Reference: Engineering Services
107 Neill Thomas Road
Lillington, NC
Project No.: 1801-010358

A representative of Tyndall Engineering & Design (TE&D) has observed the following items:

FIRST FLOOR PLAN
 1/4" = 1'-0" CEILING HGT. = 10'-0"

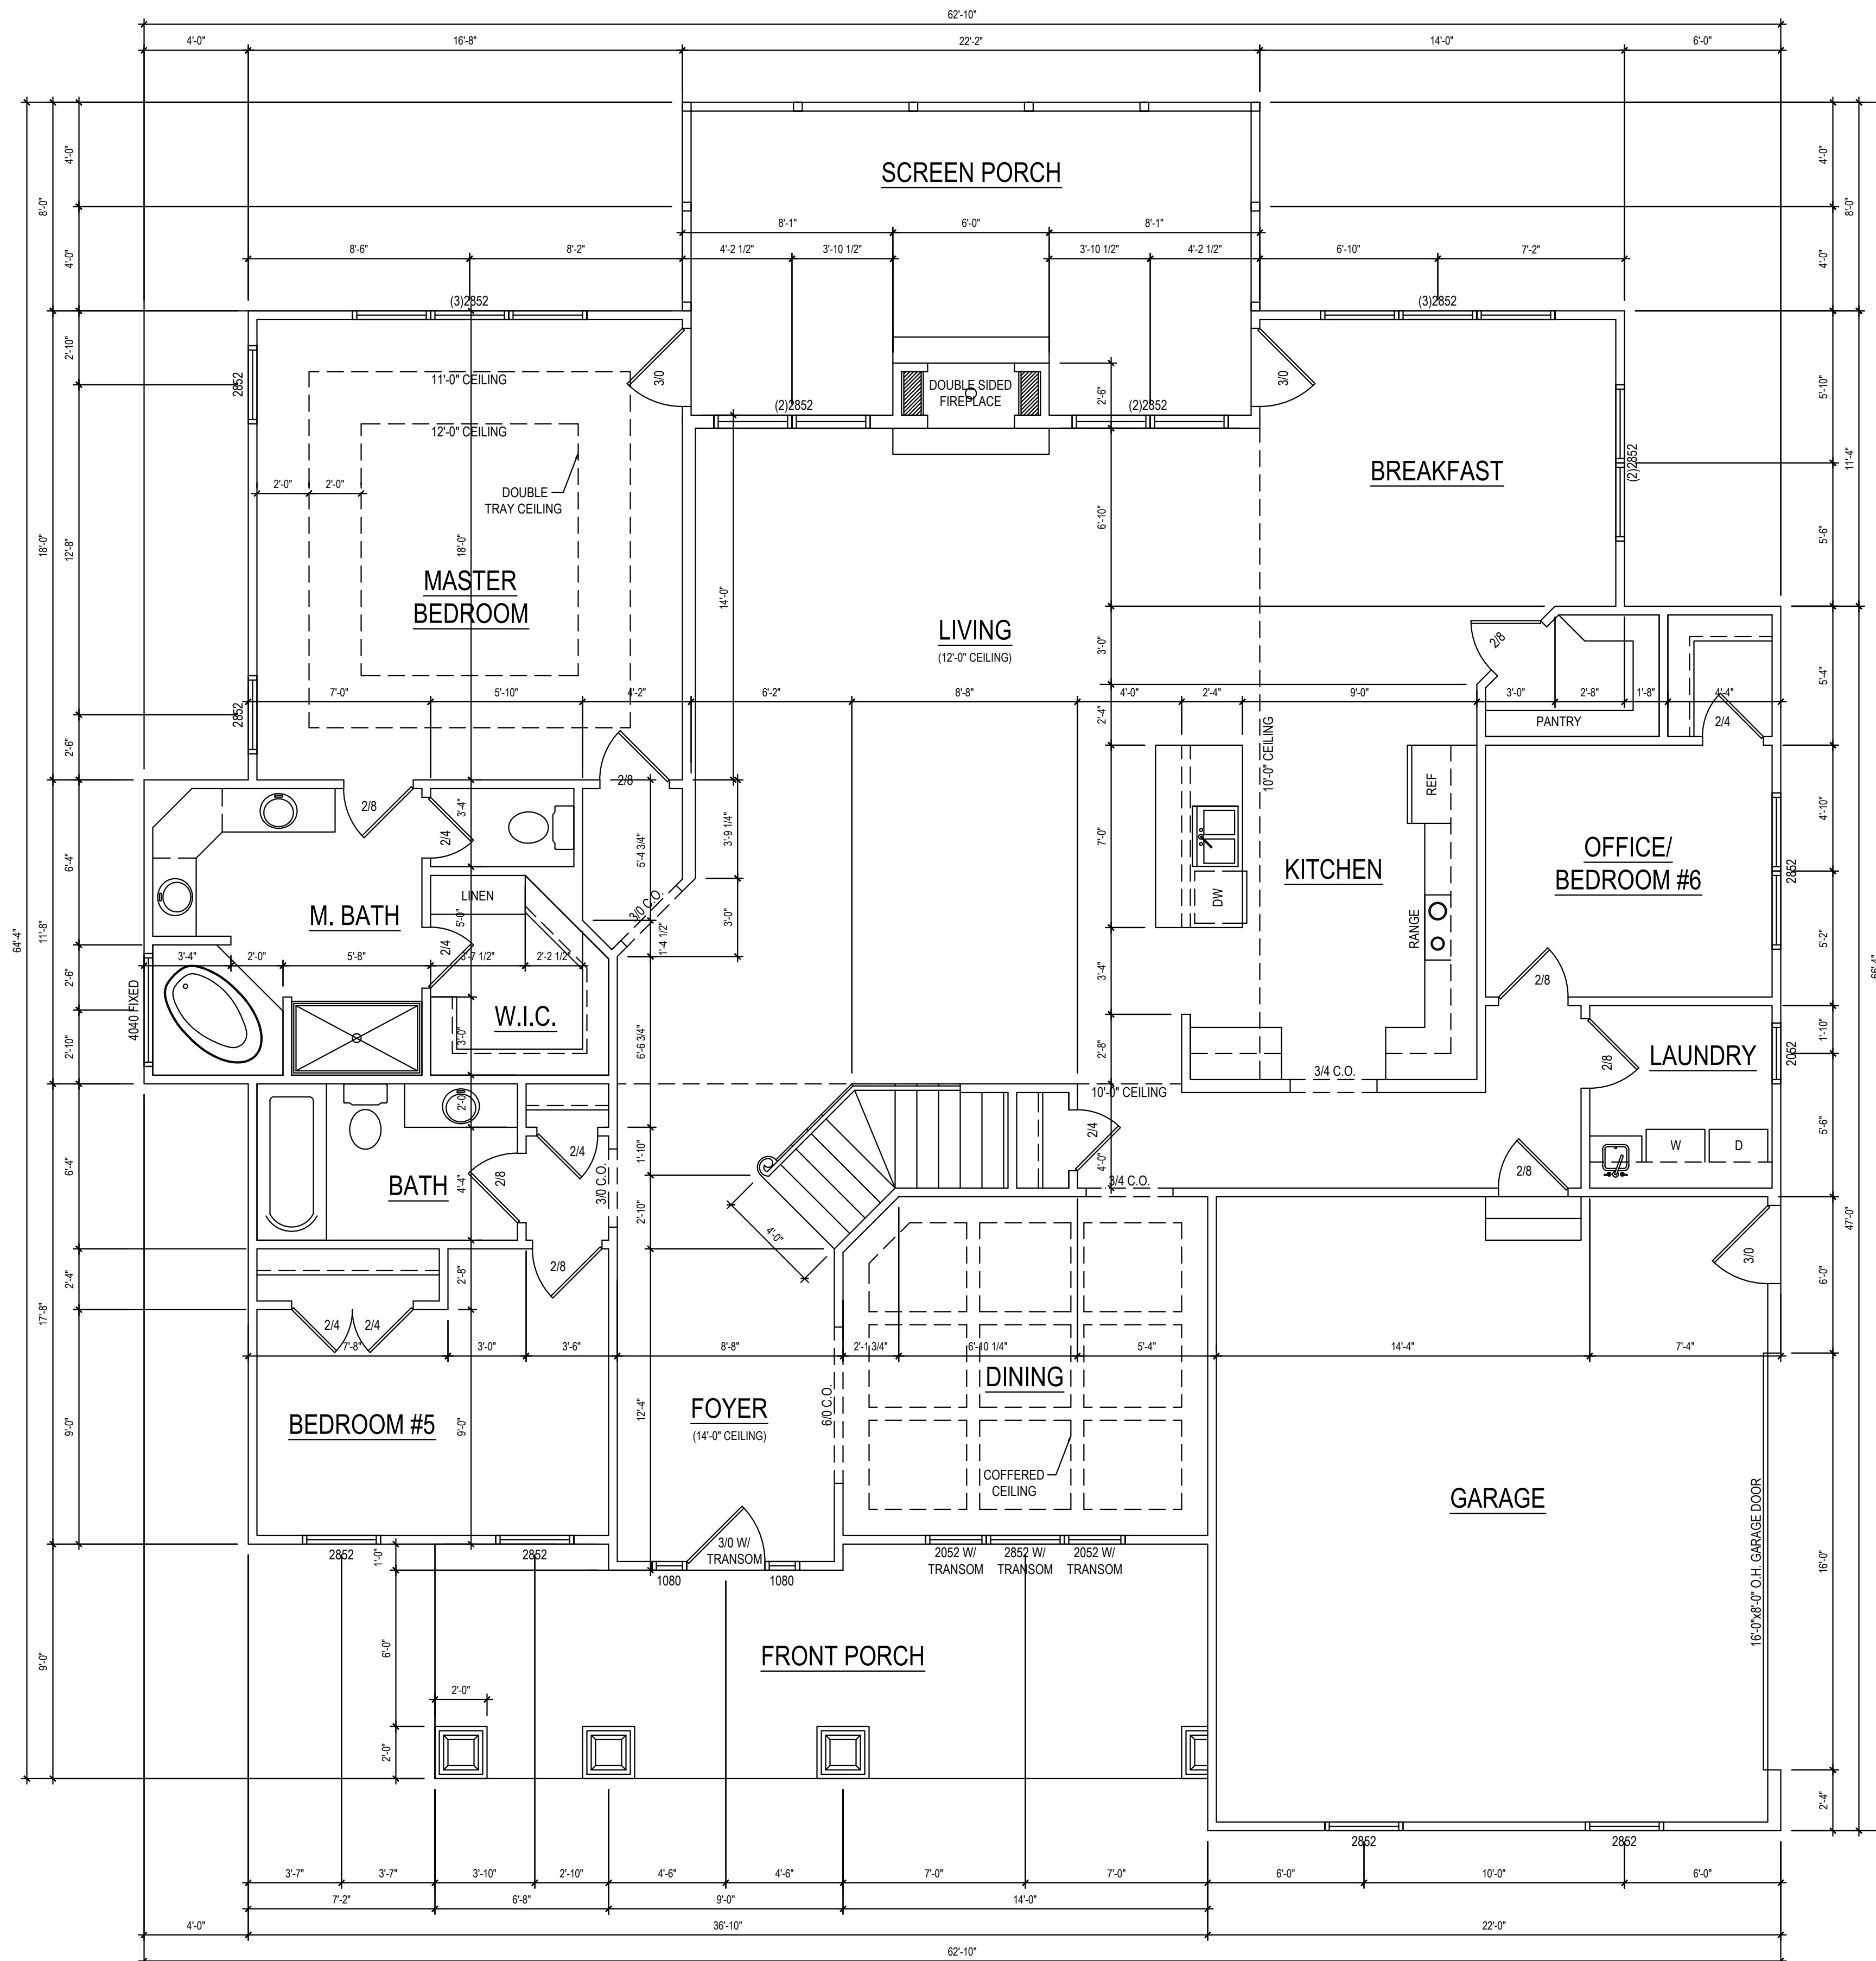
- 1) Dormer located above bedroom 5 relocated aft 32".
- 2) SPF top plate in-lieu of the plan specified SYP top plate at the living room/kitchen steel beam.
- 3) Notched (2) 11-7/8" LVL beam bearing in the W21x44 steel beam flange at the rear right living room wall.
- 4) Modified door opening at the second-floor theater room.
- 5) 24" O.C. bolting pattern at the per Detail A for the W21x44 steel beam at the living room.

- 2) Based on our observations and analysis, the existing SPF top plate is adequate as constructed to support the anticipated loading conditions.
- 3) Based on our observations and analysis, the existing notched (2) 11-7/8" LVL bearing on the bottom flange of the steel beam coupled with the plan specified Simpson HHUS410 hanger is adequate as constructed to support the anticipated loading conditions.

- 5) Based on our observations and analysis, the existing staggered bolting connection is adequate as constructed to support the anticipated loading conditions.
